**KIRKLEES METROPOLITAN COUNCIL
INVESTMENT & REGENERATION SERVICE**

DELEGATED DECISION TO DETERMINE PLANNING APPLICATIONS

Reference No:	2025/62/92396/W
Site Address:	rear of, 14, Lincroft Avenue, Dalton, Huddersfield, HD5 8DS
Description:	Erection of detached dormer bungalow
Recommending Officer:	Joanna Rednall

DECISION - REFUSE

CLIENT: COLIN SMITH
SITE ADDRESS: REAR OF 14 LINCROFT AVENUE, HD5 8DS
TITLE: FRONT ELEVATION
DATE: 25/08/2025
SCALE: 1:50 @ A3

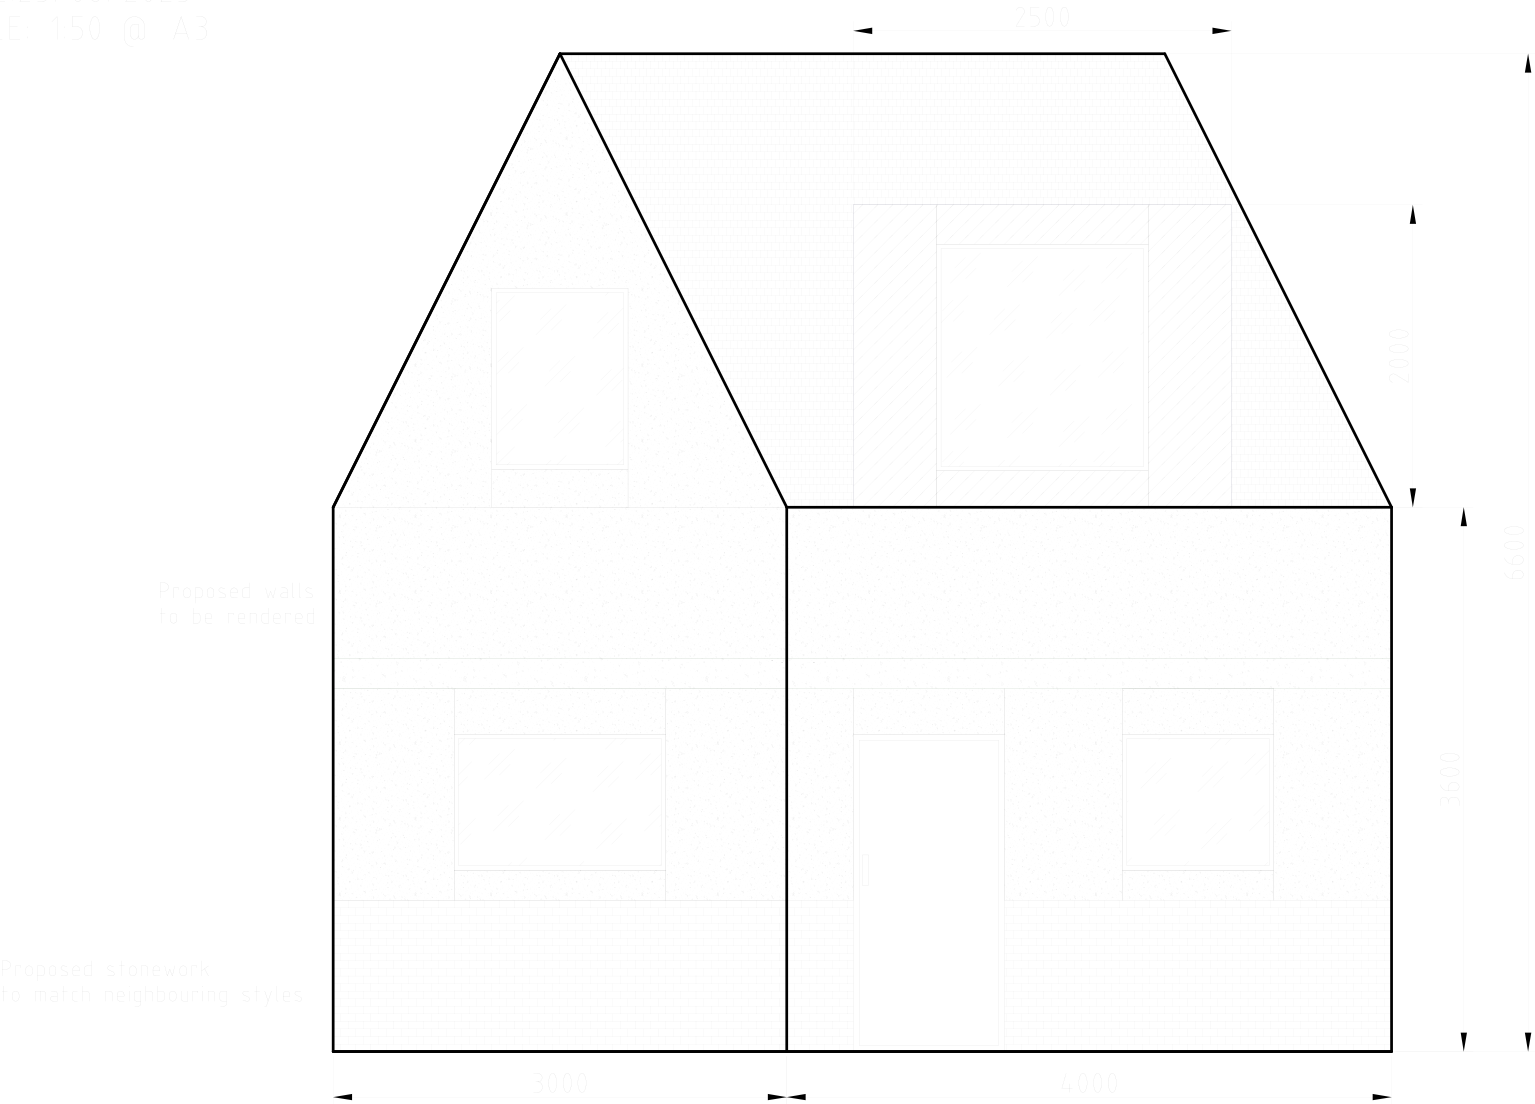
The dwelling features a hipped roof design with a large, pitched roof element and a smaller flat-roofed dormer to the front. While the architectural style attempts to reflect a modest bungalow form, the overall scale, massing, and proportion of the development are considered excessive in relation to the plot.

Specifically, the proposed built form spans approximately 6.6 metres in height and occupies a significant portion of the site's depth, leaving very limited space around the property. The resulting development appears overly dominant within the plot, with vertical massing that does not respond sympathetically to the surrounding context. Furthermore, the proposed parking arrangement to the front and side appears constrained and poorly integrated, contributing to a contrived layout.

The proposed windows and doors are of a traditional design, incorporating smaller openings at ground level with two larger windows proposed within the front dormers. This window style is consistent throughout the dwelling and includes the addition of three rooflights on the rear roof slope. However, when considered in the context of the prevailing character and appearance of neighbouring dwellings, the scale and design of the dormers are considered overly large and visually intrusive. Front dormers are not a characteristic feature within the surrounding street scene, and as such, the proposed fenestration would appear incongruous within its setting. As submitted, the proposal is not considered to comply with Principle 14 of the Council's Design SPD, which seeks to ensure that new development responds positively to local character and reinforces the established pattern of development.

CLIENT: COLIN SMITH
SITE ADDRESS: REAR OF 14 LINCROFT AVENUE, HD5 8DS
TITLE: REAR ELEVATION
DATE: 25/08/2025
SCALE: 1:50 @ A3

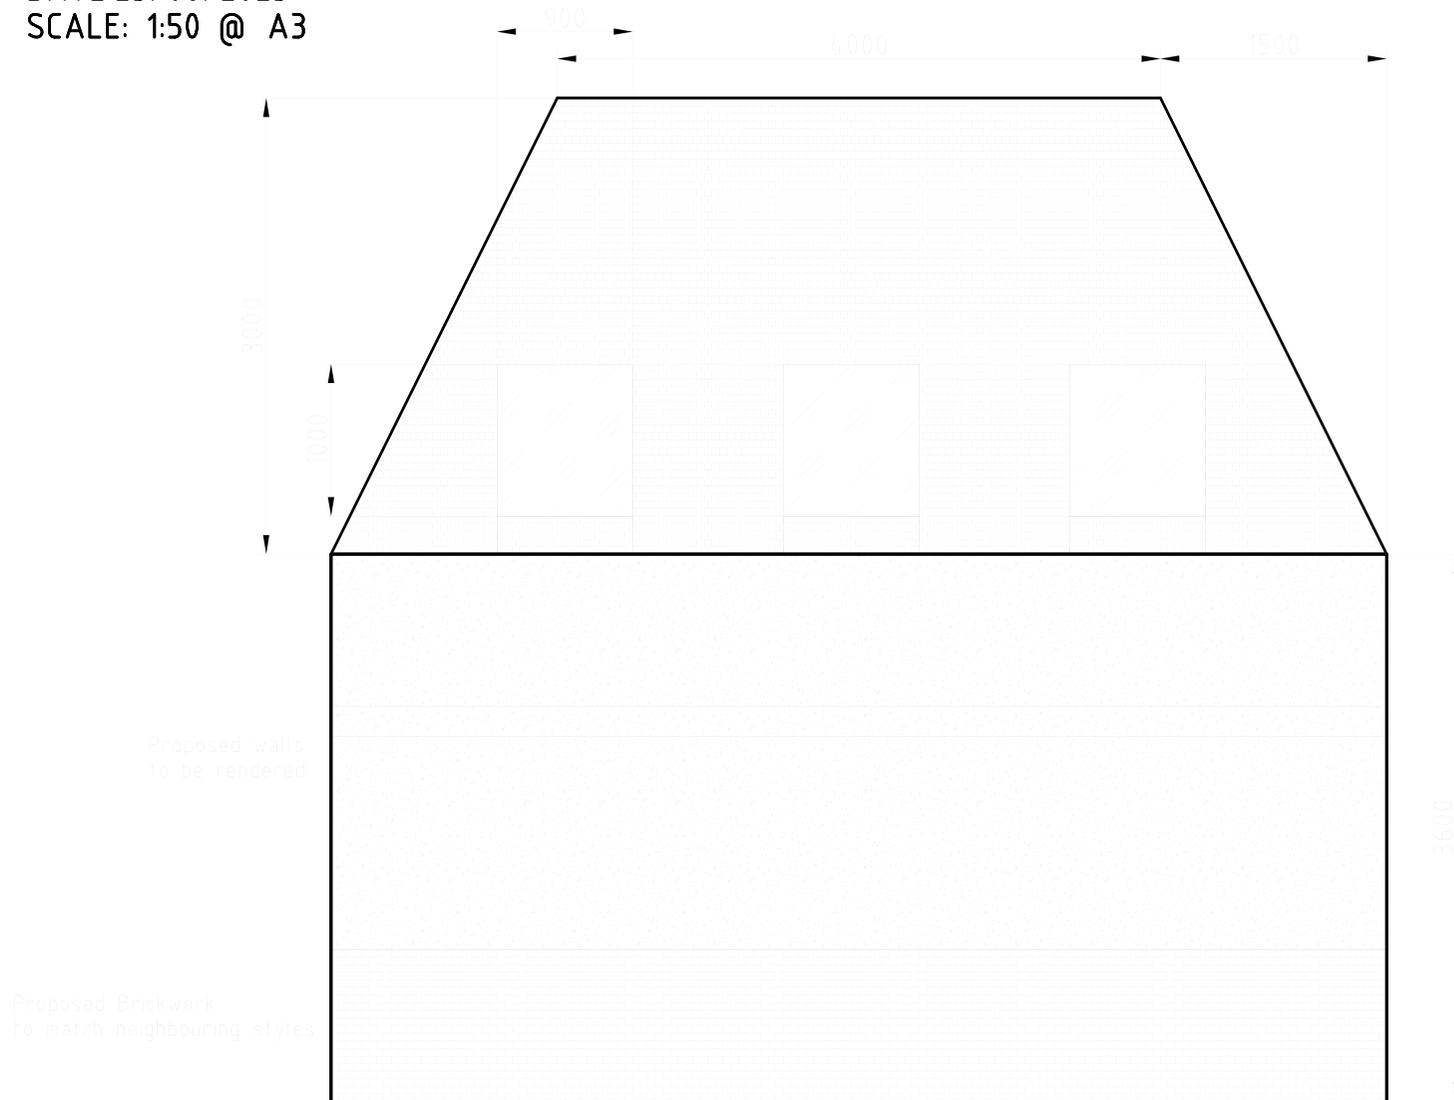
In terms of the impact of the proposed development on the privacy of neighbouring properties, the submitted plans indicate several openings: ground and first-floor windows to the front elevation, one ground-floor window on each side elevation, and three rooflights within the rear roof slope.

With regard to the three proposed rooflights on the rear roof slope, these would face towards No.16. However, given their positioning within the roof and typical upward-facing orientation, it is not anticipated that they would offer direct or harmful views towards neighbouring properties. As such, they are not considered to result in any significant loss of privacy.

Site Plan showing Driveway and Bin Store

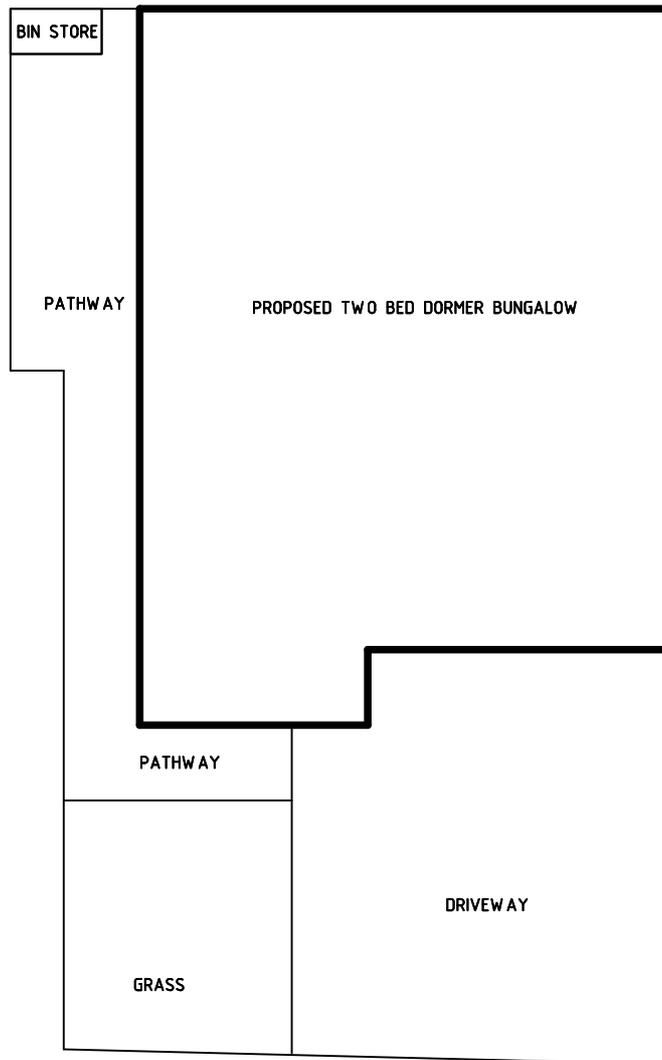
The proposal seeks to erect a dormer bungalow within an existing rear garden area measuring approximately 200m². According to the submitted site plan, the footprint of the proposed dwelling would be approximately 62m². The layout includes a driveway and a small lawned garden to the front, with a footpath along the side elevation leading to a designated bin store.

The proposed dwelling includes predominantly hardstanding to the front and side of the property, with a modest area of soft landscaping to the front measuring approximately 2.8 x 3 metres. This space is also intended to serve as the main external amenity area for the dwelling. As proposed, the frontage would be largely dominated by hard surfacing, resulting in a vehicle-dominated appearance that would sit somewhat at odds with the character of the surrounding street scene. While it is recognised that the design of the dwelling limits the available options for off-street parking, this reflects the overall constraints of the plot, which does not comfortably accommodate a layout that balances car parking provision with proportionate soft landscaping in a visually sympathetic way.

The proposal would provide a 2.8m x 3m area of outdoor amenity space in a prominent location to the front of the site. The level of space provided is somewhat limited given the size of the proposed dwelling and also constraints of the site in terms of its overall size and the access arrangements / need to provide suitable access and parking arrangements.

For a 2-3 bedroom dwelling, KC Highways would require 2 off-street parking spaces, and officers would not accept any on-street parking in this case due to the location of the site. To accommodate parking for 2 cars, the plans must show two parking bays of minimum dimension 5.0m x 2.4m. The submitted block plan indicates parking is proposed to the front of the dwelling at a width

of 5m and of split depths, with one parking space able to achieve ~5.4m in depth and the other around 4.3m in depth due to the outshot to the front of the dwelling.

KC Highways raised an objection to the proposed development on the grounds that the scheme fails to provide adequate off-street parking provision. The submitted plans indicate that the proposed dwelling would not be capable of accommodating two vehicles within the site boundary, as only one parking space of sufficient dimensions is provided to allow a vehicle to be parked clear of the footway. As a result, one vehicle would overhang onto the adjacent footway, causing obstruction to pedestrian movement and posing a potential safety hazard. This level of provision is considered insufficient to meet the parking demand generated by a dwelling of the proposed scale and type. The shortfall in on-site parking provision is therefore likely to lead to vehicles being parked on the surrounding streets, increasing pressure on existing on-street parking and potentially compromising the safe operation of the highway.

3. The proposal fails to provide two functional off-street parking spaces proportionate to the size of the dwelling and positioned to avoid obstruction of the footway. As such, the development would result in inadequate parking provision, to the detriment of highway safety. The proposal is therefore contrary to Policies LP21 and LP22 of the Kirklees Local Plan, Chapter 9 of the National Planning Policy Framework and Principle 12 of the Council's adopted Housebuilders Design Guide SPD.
